DOC18/295427  
SSD 6456

### **Narrabri Gas Project (SSD 6456) – Response to Submissions**

Thank you for your invitation for the Office of Environment Heritage (OEH) to comment on the Response to Submissions for the Narrabri Gas Project.

Figure 15-1

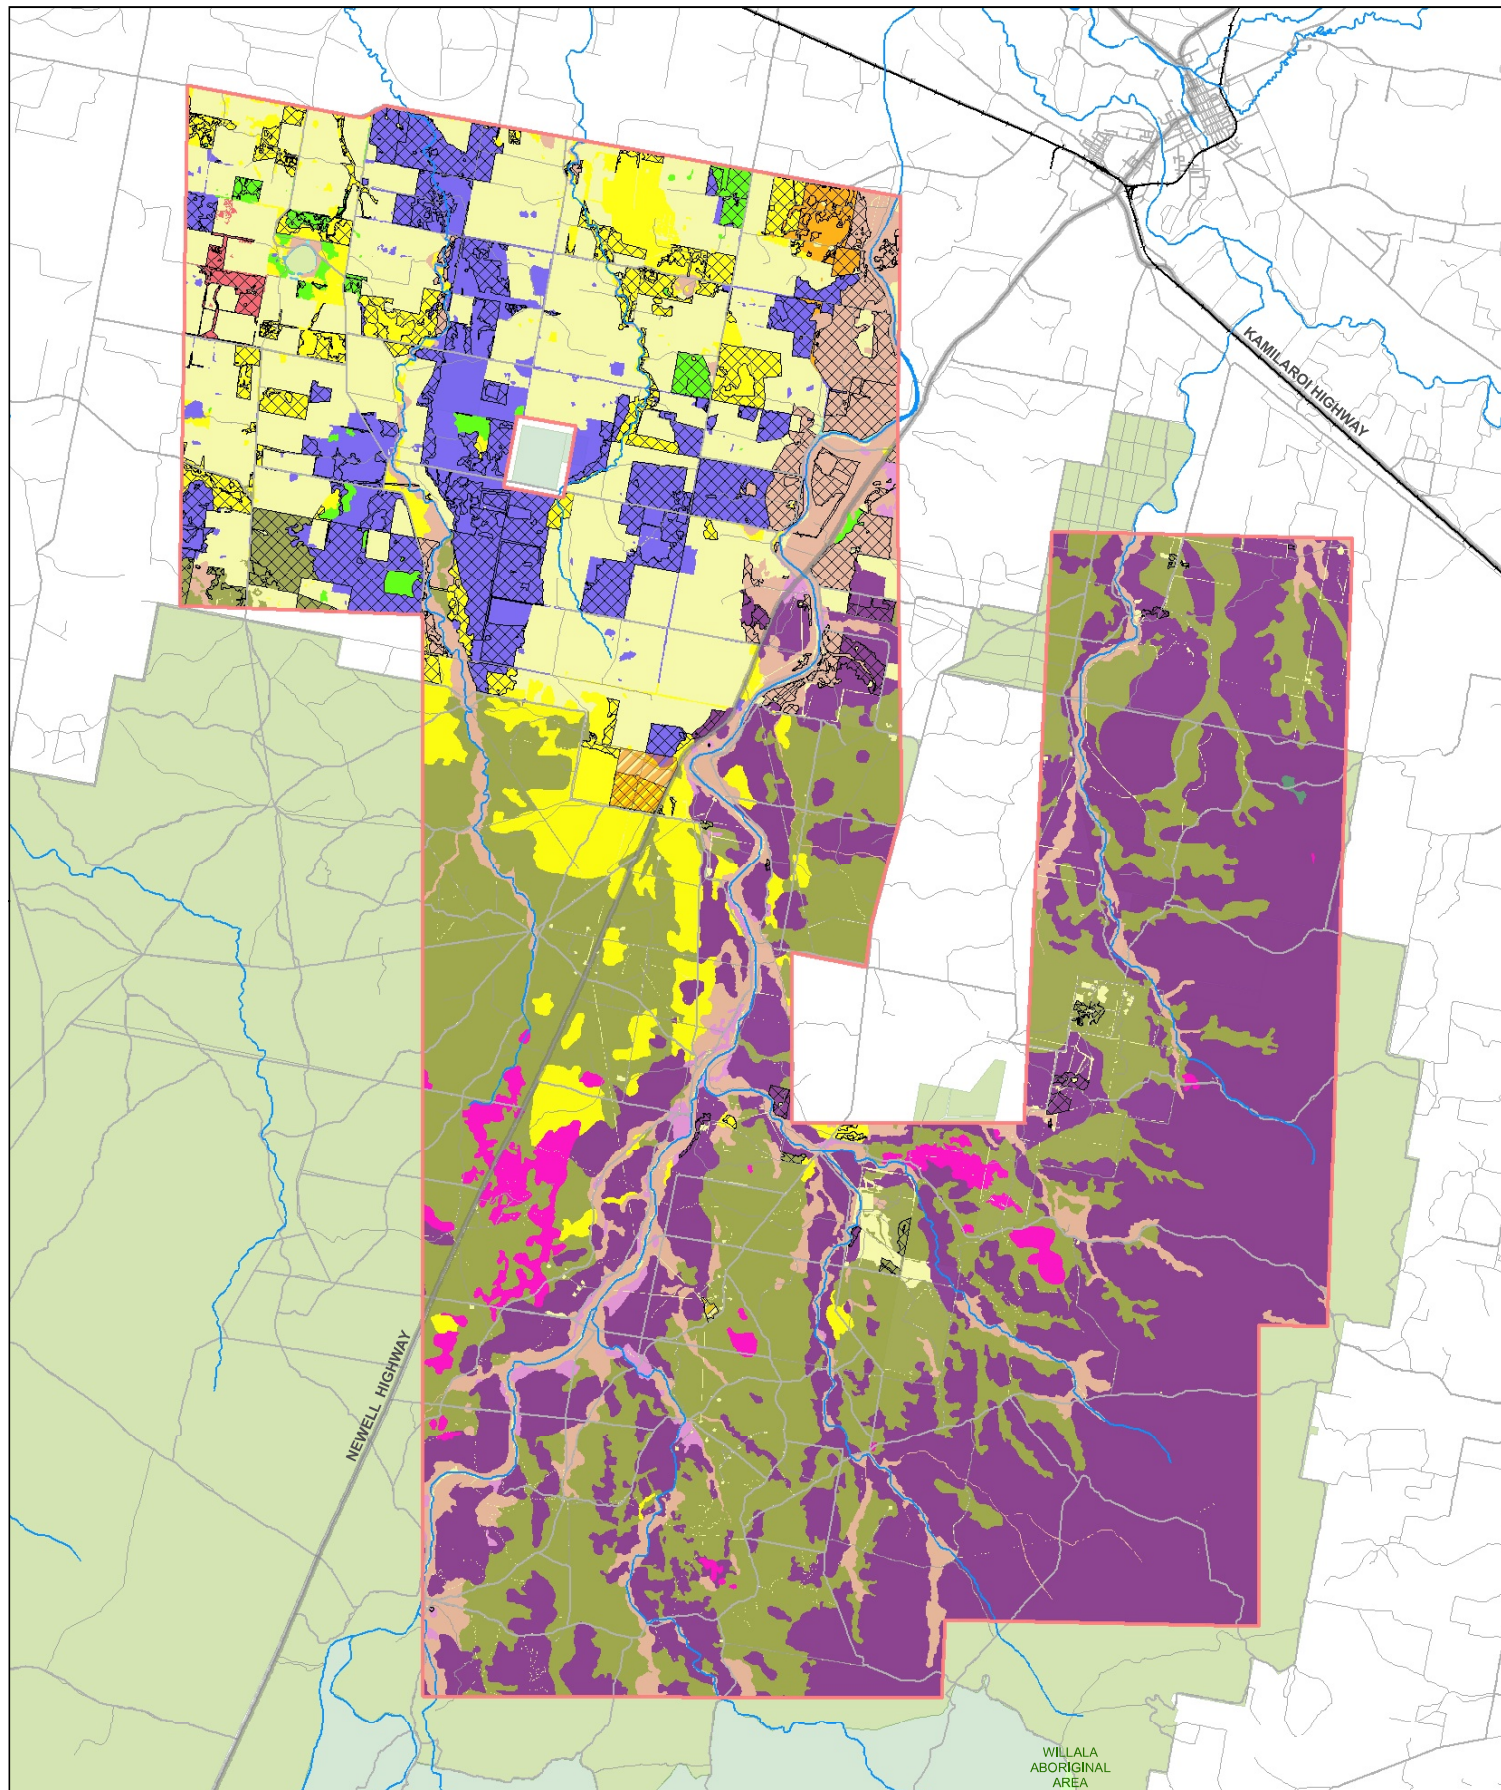
OEH still has concerns that the PCTs impacted may not be reflected in the vegetation map. There is a likelihood that the actual impact on PCTs will be different to that calculated by the mapping. For EECs this may be significant.

OEH recommends that all impact areas be ground-truthed to determine whether the PCTs mapped at the impact sites are correct. Should the PCT not be as mapped the impact may be tracked against

the upper disturbance limits for the mapped PCT should it be in the same vegetation class as the impacted PCT. Disturbance to EECs must be tracked against impacted PCTs. All variances from the mapped PCT should be reported. Where variances from the upper disturbance limits are significant against that predicted, a modification to capture the variation in the credit obligation may be required. This will allow DPE to track the actual PCTs cleared, and should they vary significantly from the mapped PCTs, DPE may consider varying the approval.
